From: Maria Tomalova <Maria.Tomalova@arun.gov.uk>
Sent: 20 August 2021 14:37
To: Planning.Responses <Planning.Responses@arun.gov.uk>
Subject: FW: Y/88/21/DOC

Subject: Y/88/21/DOC

Condition 5

SITE LAYOUT
(1:200)

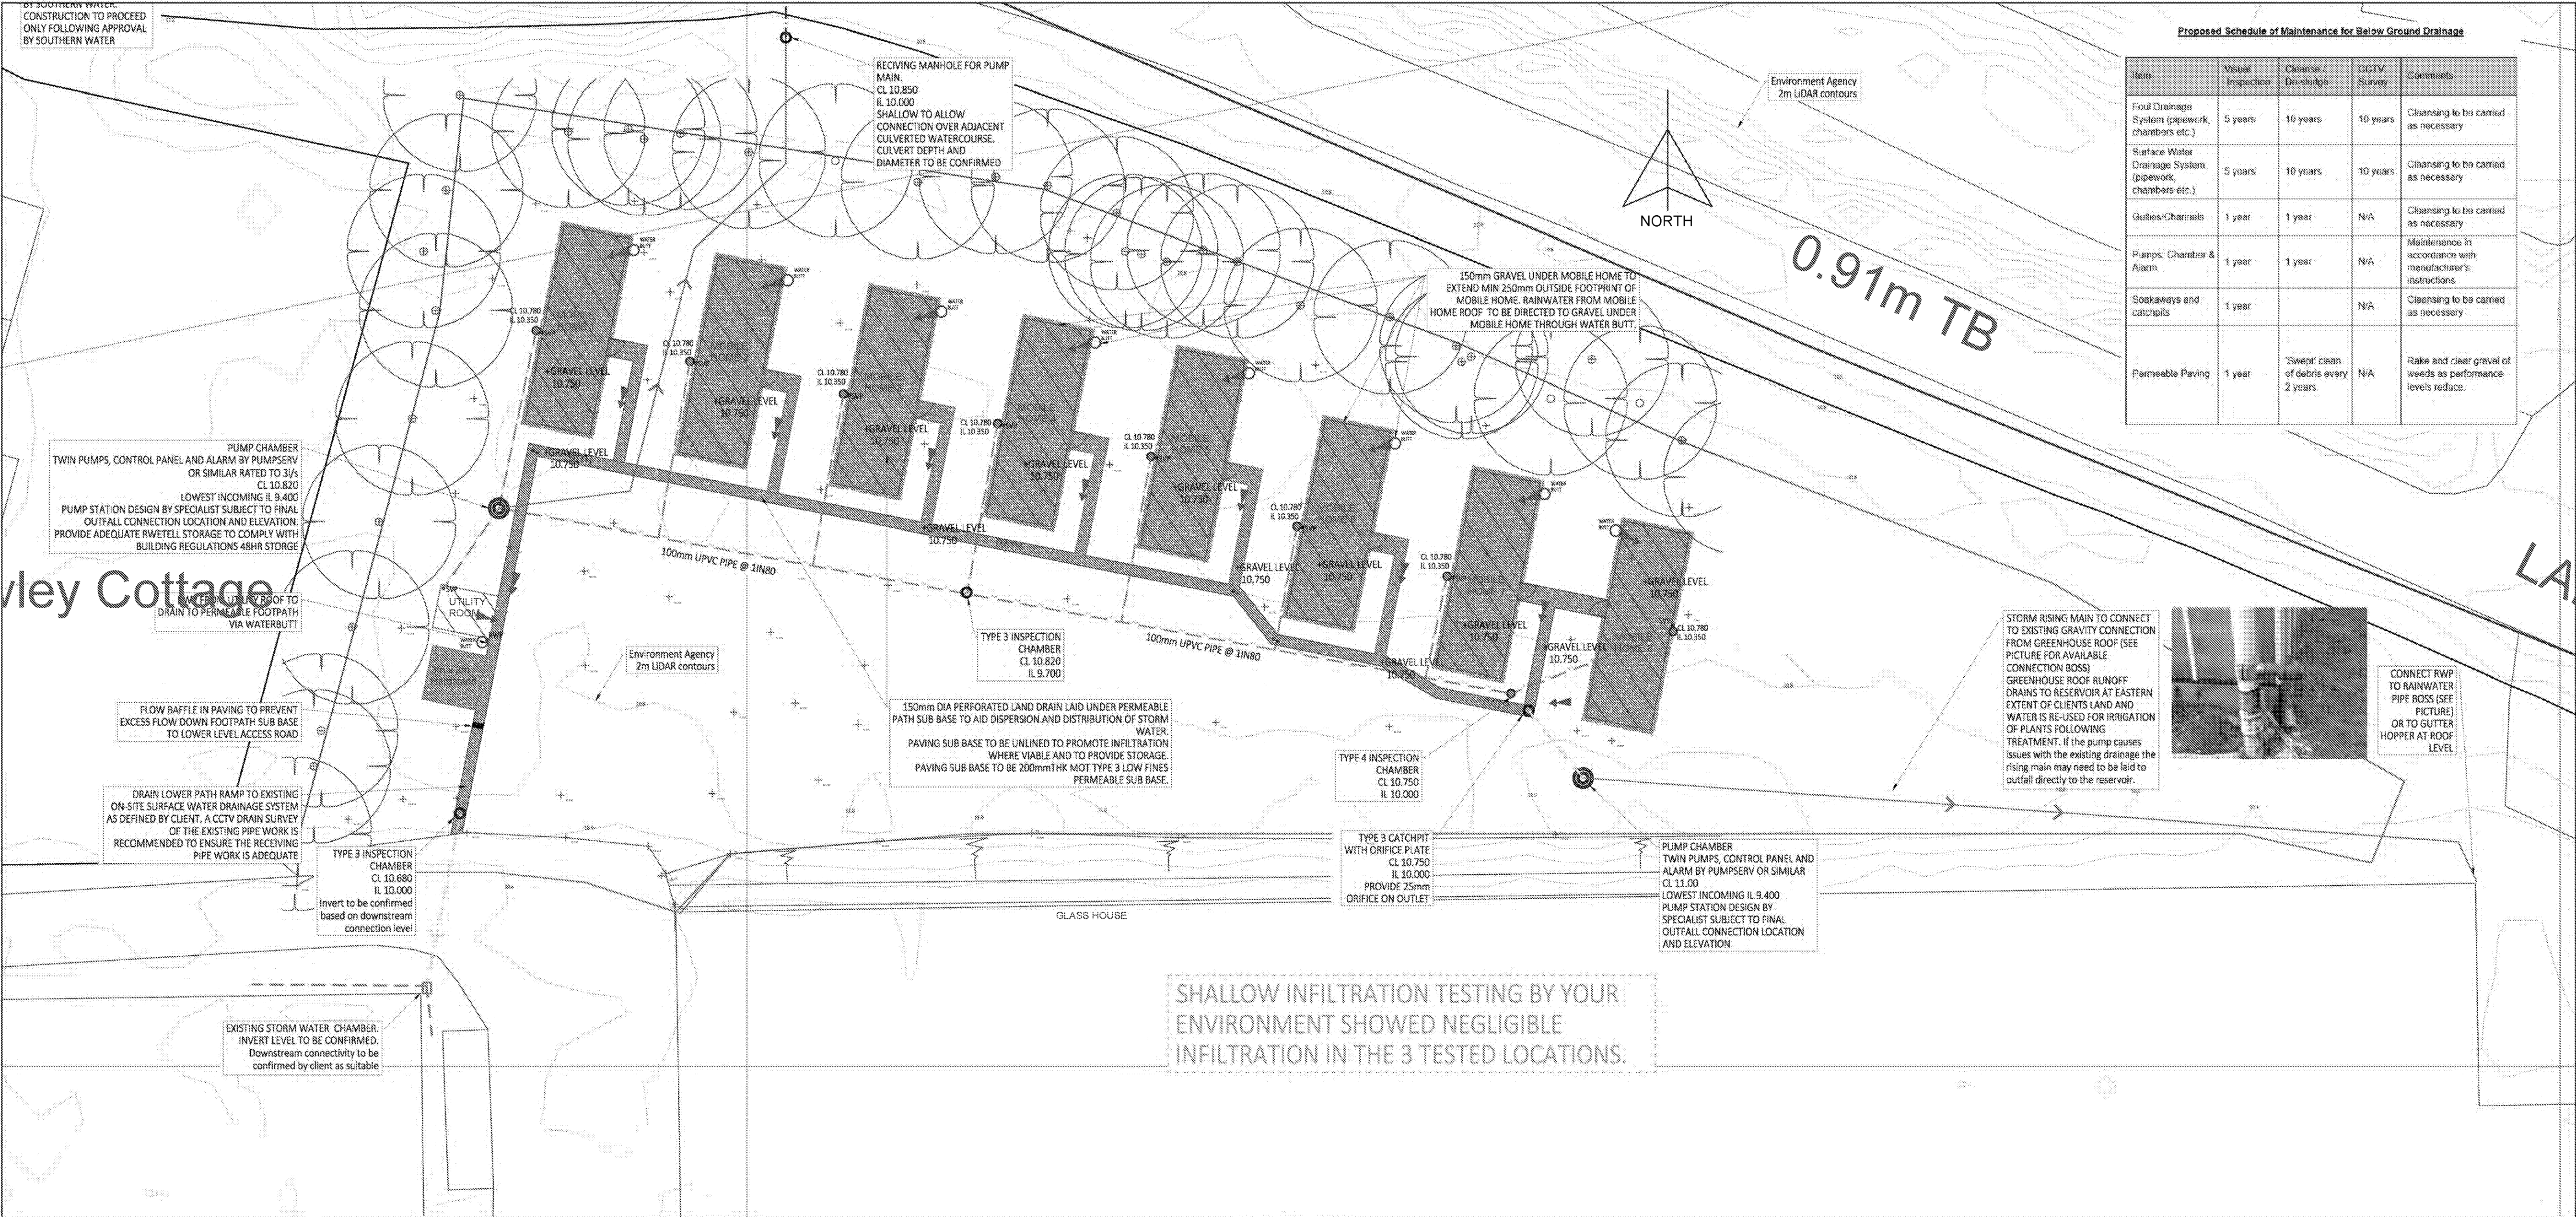
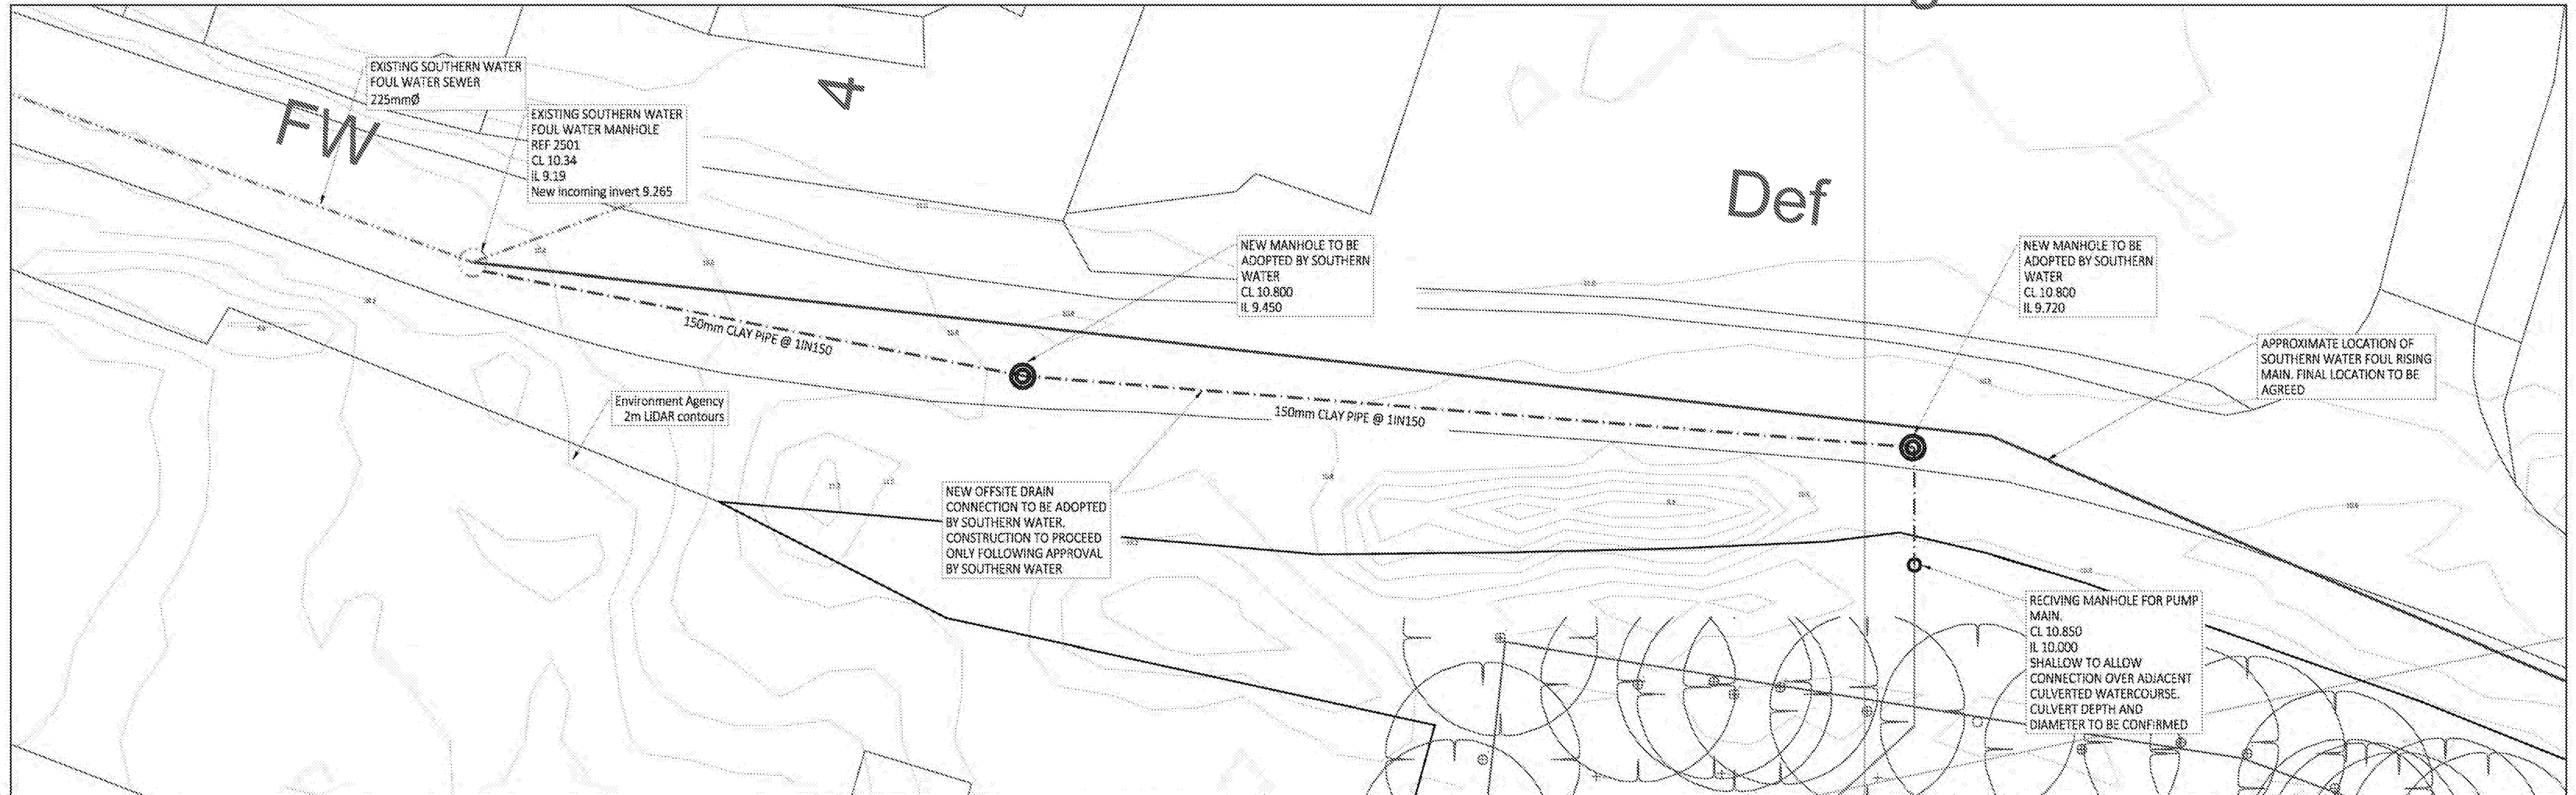
1. The applicant has completed summer infiltration testing which indicate infiltration is not viable.
2. No winter groundwater monitoring results have been provided, this information must be supplied to evidence that groundwater will not get into the surface water drainage system.

3. The proposal is for an unlined system to be pumped. This could in winter result in groundwater being pumped.
4. Pumping is not supported, it is not a sustainable solution. Pumps also fail and can result in increased flood risk both on and off site. The applicant must submit a revised gravity scheme.

5. The proposals are to pump surface water to the on site reservoir. The statement claims that no surface water will be discharged off site. No evidence has been submitted to evidence that either the existing surface water drainage network or reservoir have the capacity to accept these additional flows. The reservoir must also have an overflow to somewhere for water to be discharged in times of exceptional rainfall when irrigation demands are less, i.e. the winter. Therefore the statements provided are not supported by ourselves.

It is not possible for us to recommend discharge of this condition at this time with the strategy presented. A fully revised surface water drainage design is required, which may involve a gravity outfall to watercourse.
